Rampion 2 Offshore Wind Farm (Project Reference: EN010117)

Deadline 4 Submission (3 June 2024)

West Sussex County Council (IP Reference 200445228)

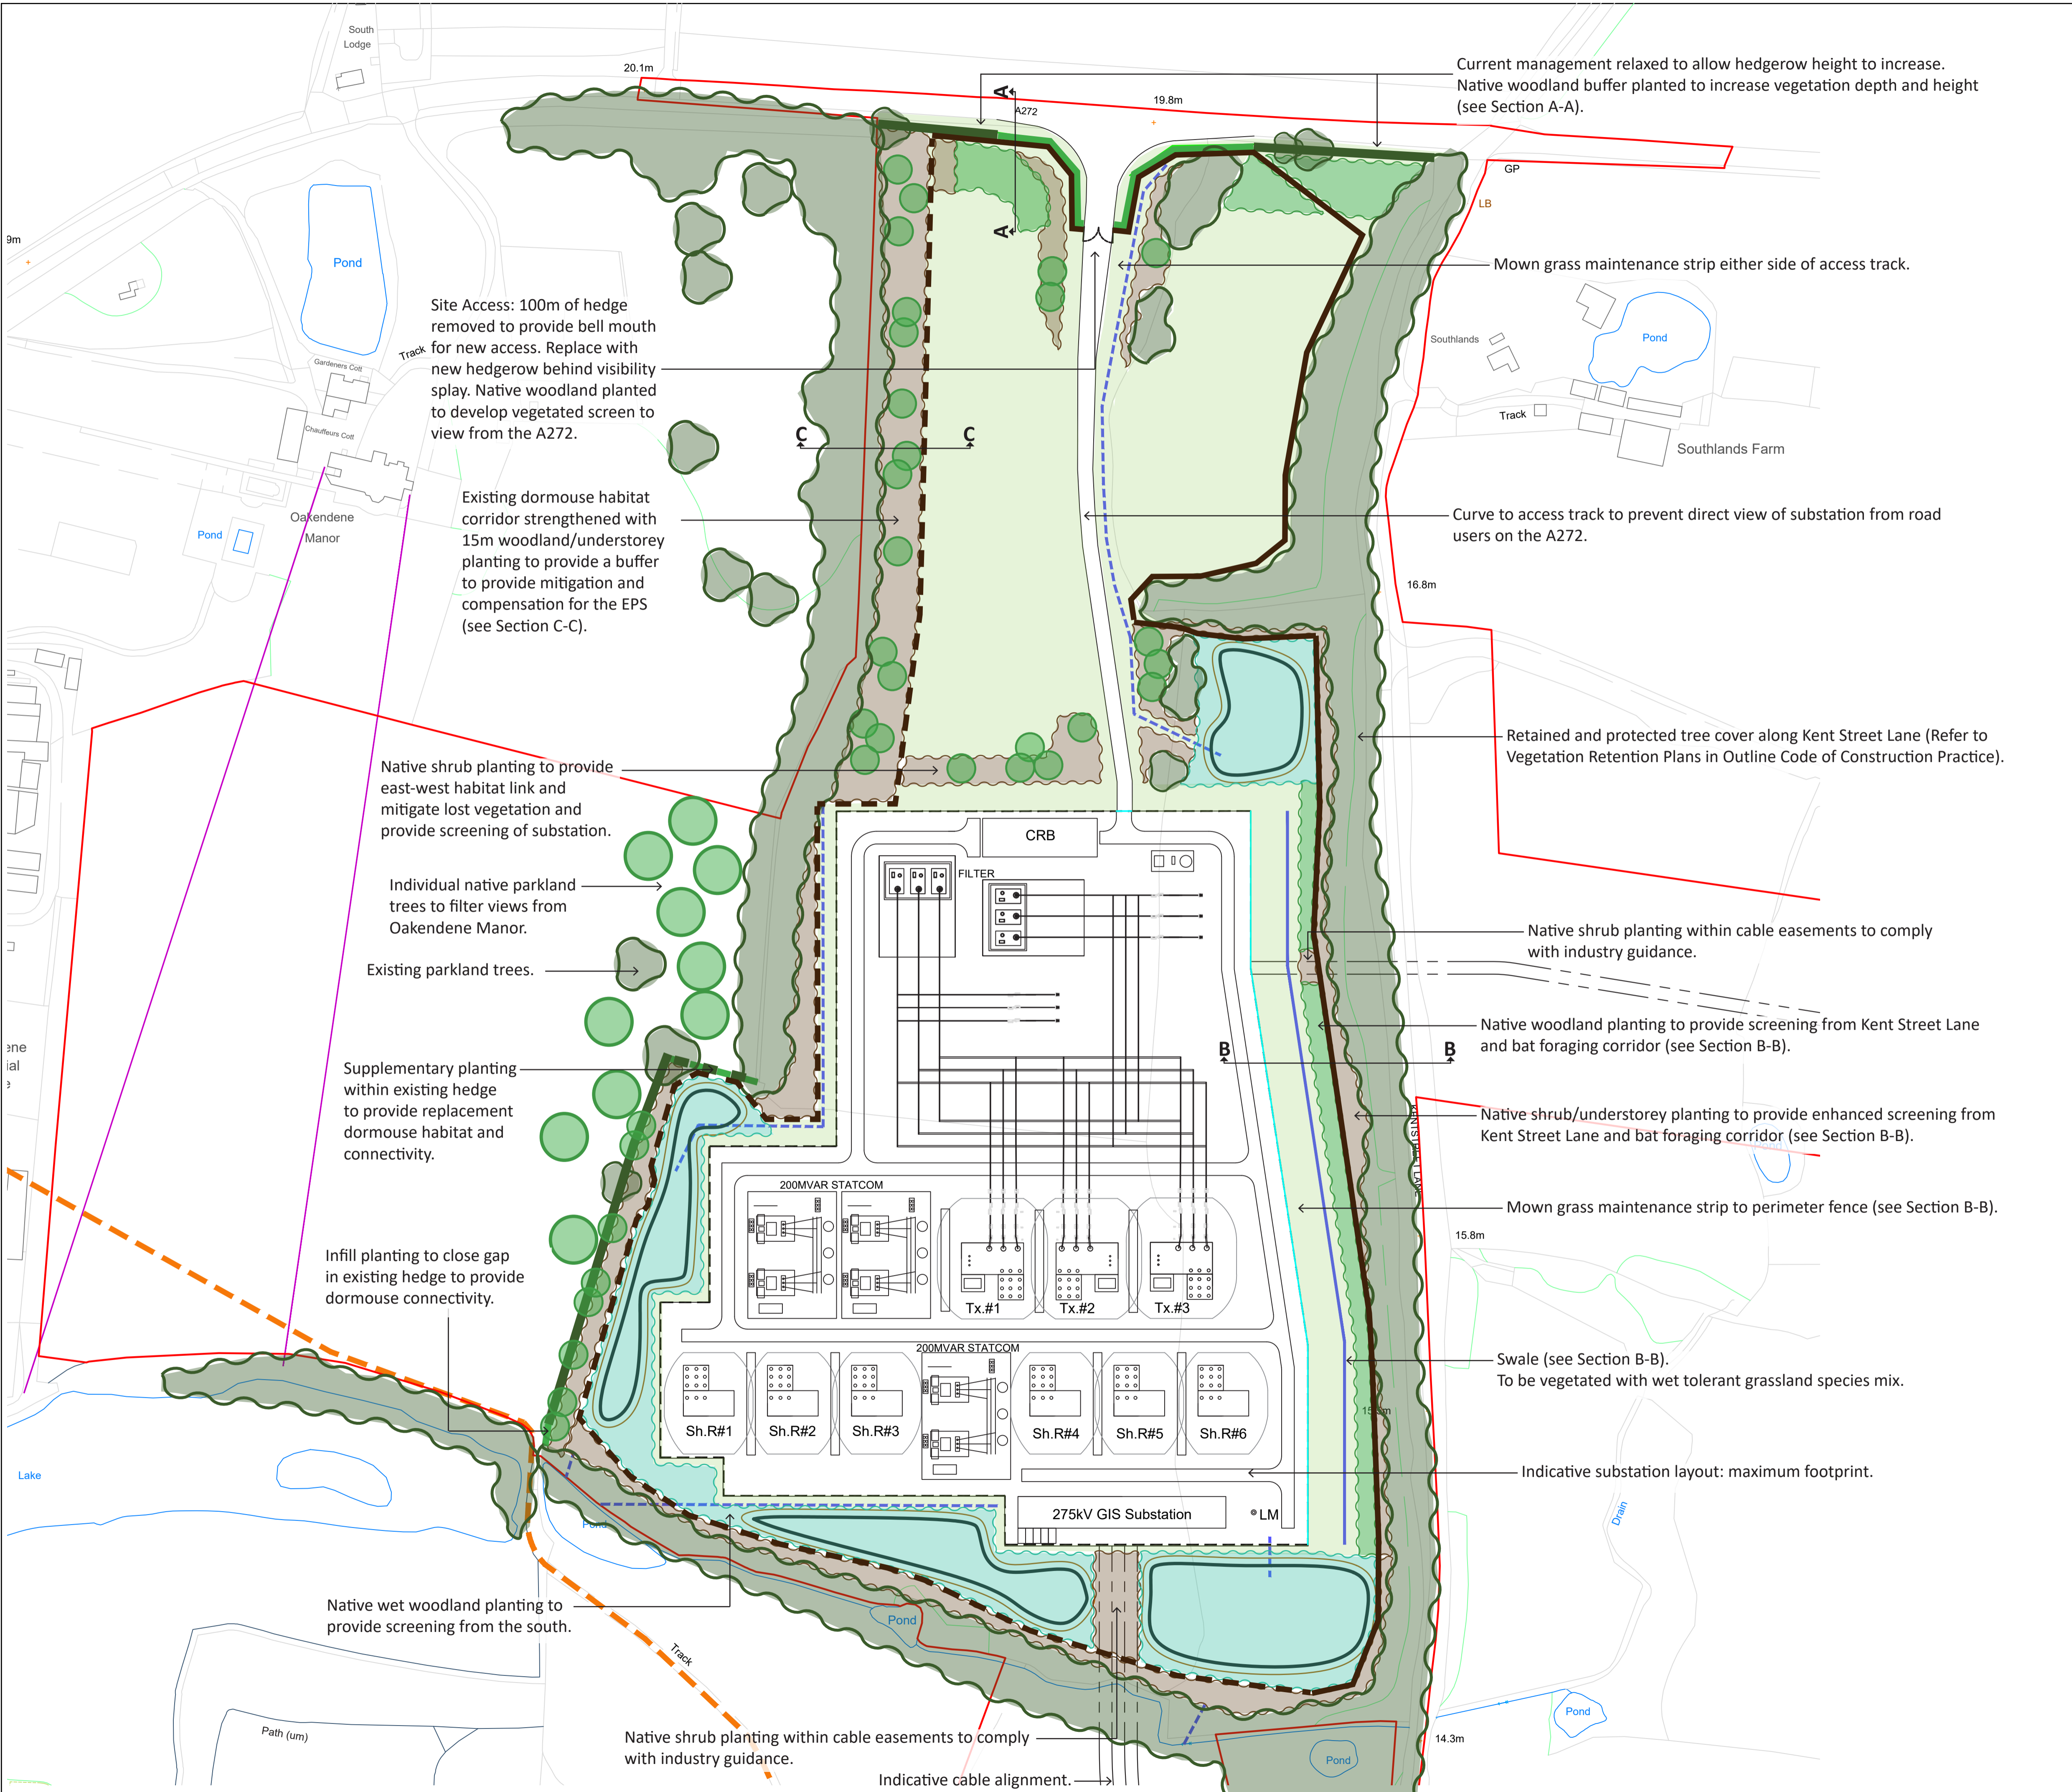
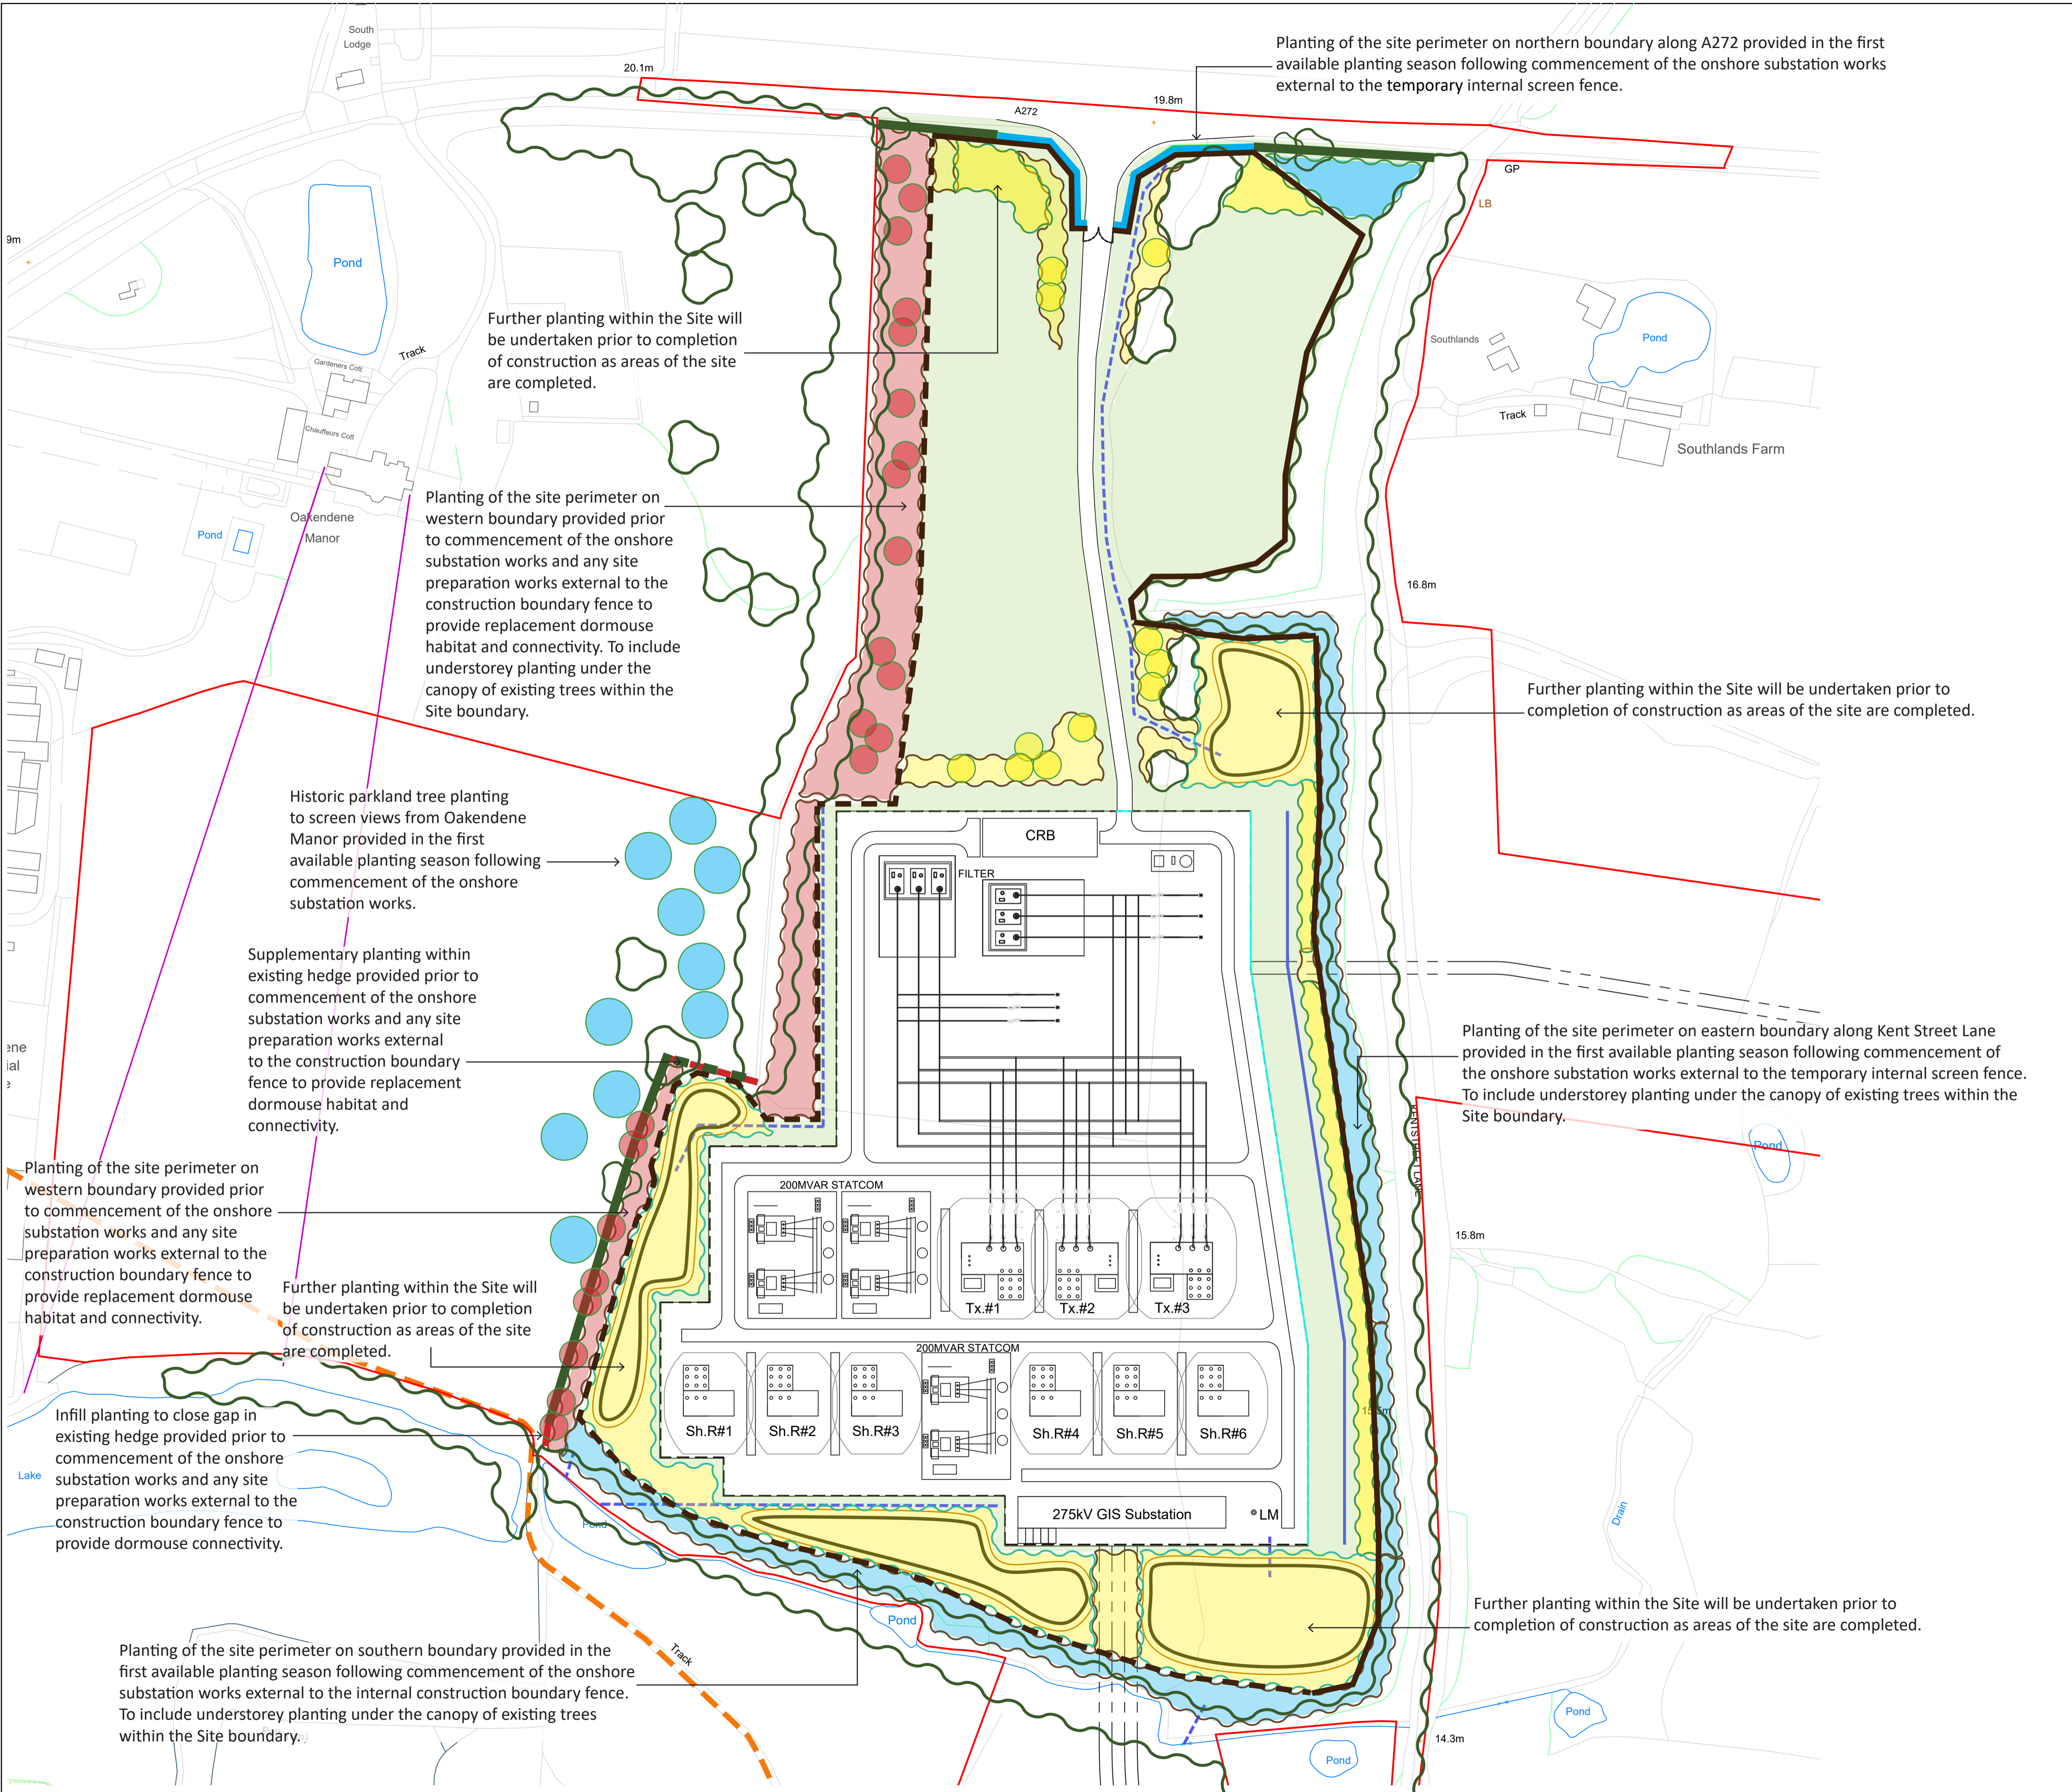
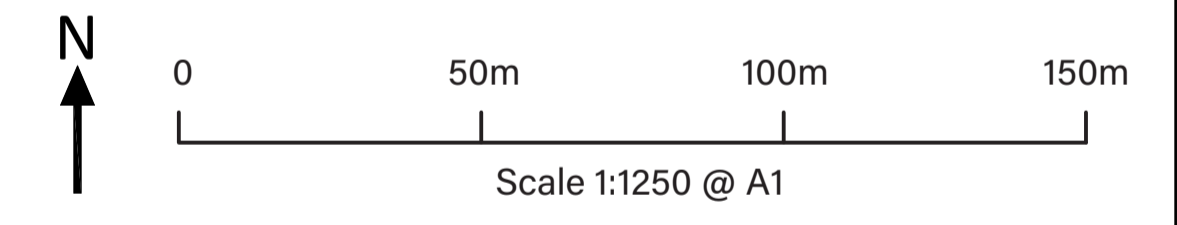
- Regarding the updated Oakendene Substation Indicative Landscape Plan, the additional planting/updated planting provision is welcomed (e.g. at the access and to the south west corner). However, it is somewhat concerning that the native woodland planting belt along the east of the site (adjacent to Kent Street) seems to be narrower, which could potentially reduce its screening effect. Further along this boundary, the plan notes '*Retained and protected tree cover along Kent Street Lane*', however, this seemingly conflicts with the latest VRPs in the OCoCP, which show this as a hedgerow '*cleared to 20m*' – this is of concern given the screening effect of the mature existing boundary.
